WEST SUSSEX COUNTY COUNCIL CONSULTATION

TO:	Arun District Council FAO: Amber Willard
FROM:	WSCC - Highways Authority
DATE:	29 October 2020
LOCATION:	Knighton Chambers 39 Aldwick Road Bognor Regis PO21 2LN
SUBJECT:	BR/231/20/PD Notification for Prior Approval under Class O for change of use from office use (Class B1a) to residential (Class C3) - Conversion of existing office building into 15 No. self-contained residential units. [Please refer to the attached Planning Statement for full details.]
DATE OF SITE VISIT:	n/a
RECOMMENDATION:	Advice / No Objection
S106 CONTRIBUTION TOTAL:	n/a

Site Plan As Proposed

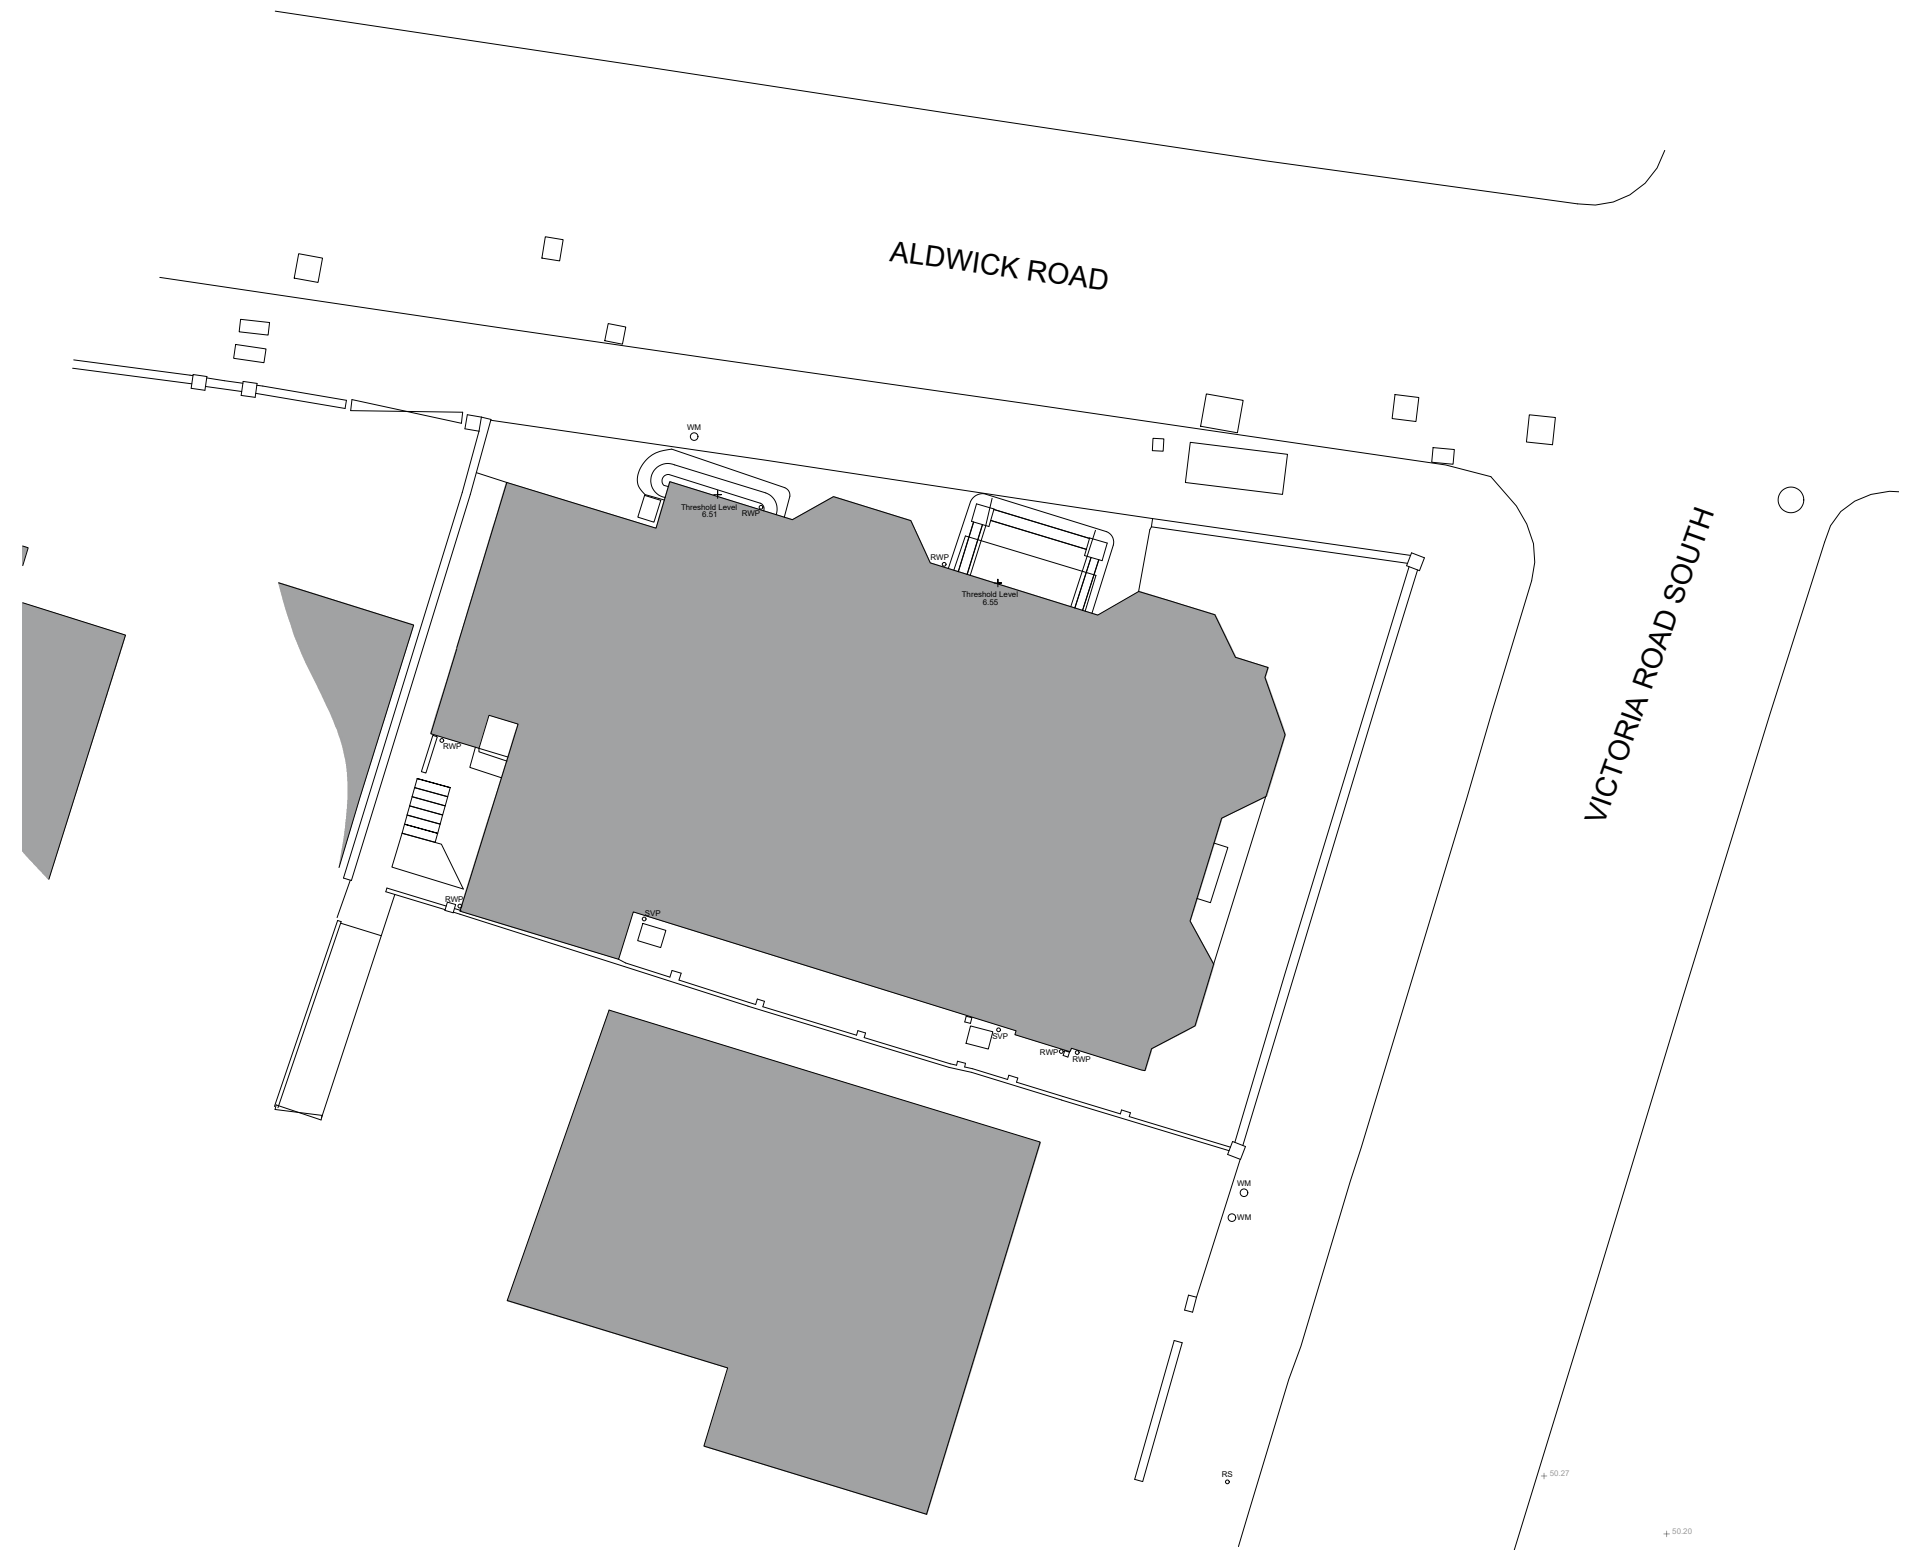
In terms of parking, there is none on site currently and there is none proposed. Whilst this is not ideal for a residential development it appears that there are opportunities to park on street or in a car park that is close by. In terms of highway safety, key locations of the highway network around the site are protected against parking taking place in locations that may cause a highway safety issue. As parking would not be accommodated on site, but key locations of the highway network are protected there are no highway grounds to resist the proposal. The Local Planning Authority (PLA) may wish to consider parking from an amenity perspective though. The Planning Statement refers to the new WSCC guidance on Parking in New Developments. However Arun District Council have their own Parking Standards Supplementary Planning Document so this should be referred to.
